3 February 2020

Graham Cooper
Mirvac Projects Pty Ltd
via email: graham.cooper@mirvac.com**Response to EPA: Groundwater Seepage and Disposal
Site 53, 2 Figtree Drive, Sydney Olympic Park, NSW**

Following receipt of EPA comments titled "*Groundwater Seepage and Disposal*" reference DOC19/1111304-4 dated 23 January 2020 on the proposed Water Cycle Management Plan (WCMP¹) to address Development Consent condition E8, please find below clarification on the issues raised.

Figure 4 – Schematic layout of rainwater harvesting and re-use strategy

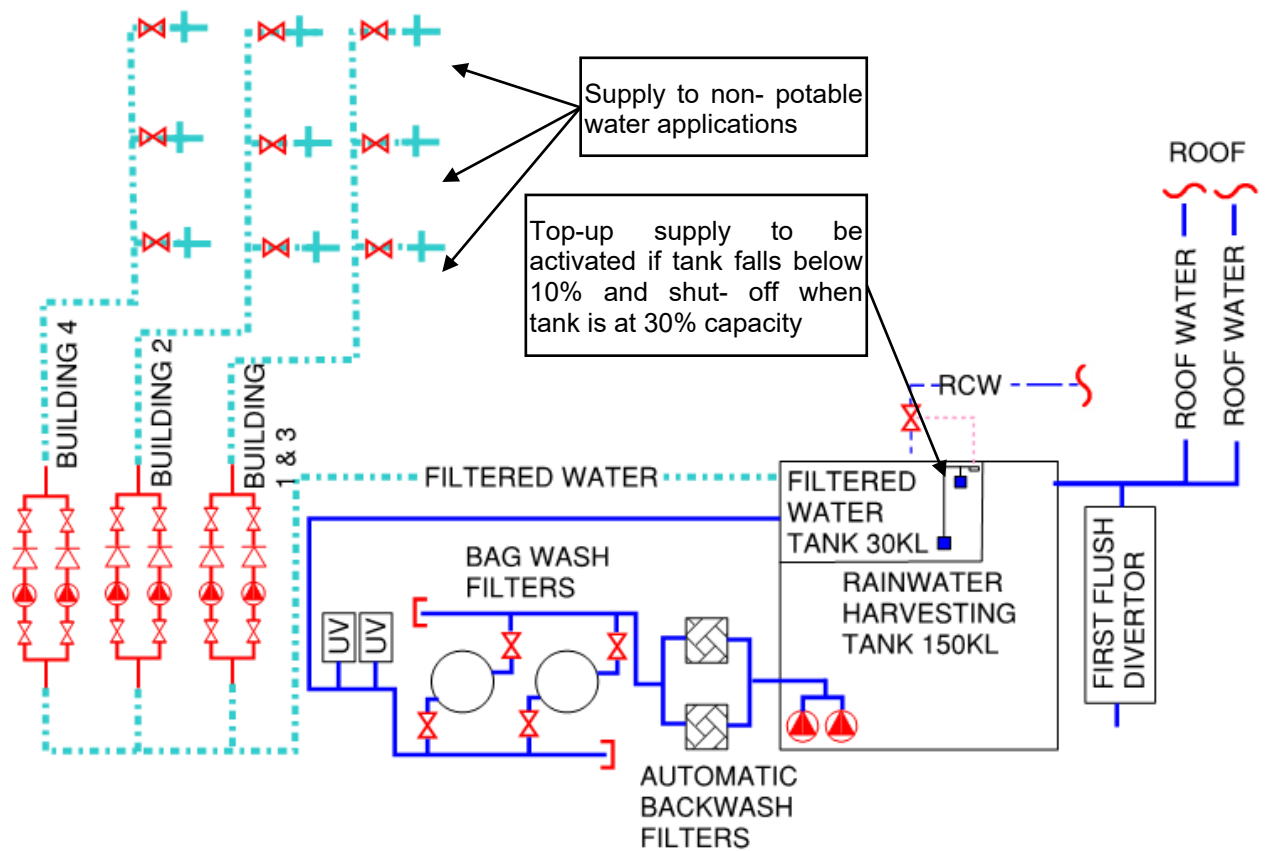
Locally harvested rainwater appears to be a source of non-potable water. The plan states, however, that this could be supplemented by recycled water, as a back-up if harvested rainwater is insufficient to meet demand.

Please refer to response provided above.

Figure 5 – Seepage Water Pump- Out Pit

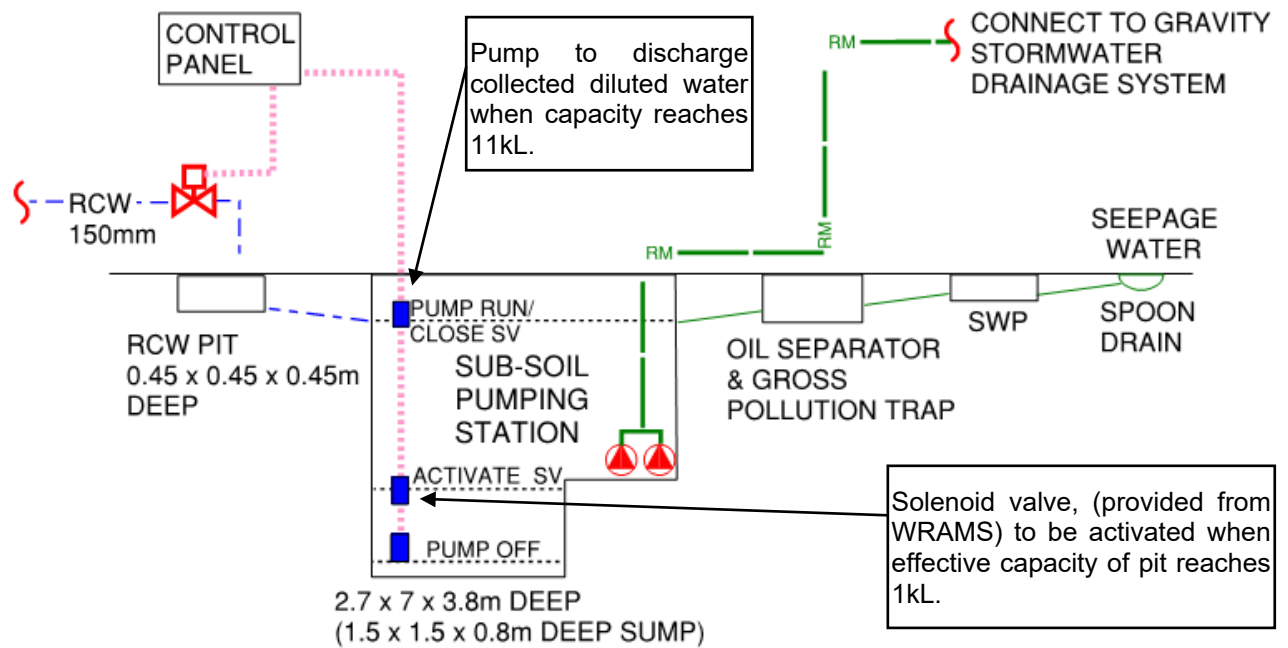
Stormwater and groundwater are separate entities and stormwater should not be used for the dilution of contaminated groundwater.

- The ammonia values are highly elevated. It should be noted that nutrient-related impacts can occur through both concentration and loads. Therefore, the proposed dilution would not address all potential risks to downstream waters based on loads. In addition, the proposed 10:1 dilution ratio would not protect downstream waters from potential nutrient concentration related risks. Based on the analysis of just two samples, the ammonia levels could be much higher under different conditions.

It is acknowledged that stormwater and groundwater are separate entities and stormwater should not be used for the dilution of contaminated groundwater.

freshwater ecological receptors. Notwithstanding, as another level of conservatism, rather than discharge collected groundwater seepage to the municipality stormwater network, Mirvac propose to beneficially reuse collected groundwater seepage within the site for the irrigation of landscaped areas of the site. Locally harvested rainwater will supplement collected groundwater seepage, as back up if groundwater seepage is insufficient to meet demand and not to dilute the groundwater seepage. Please see edits to the WCMP confirming details of the proposed system.
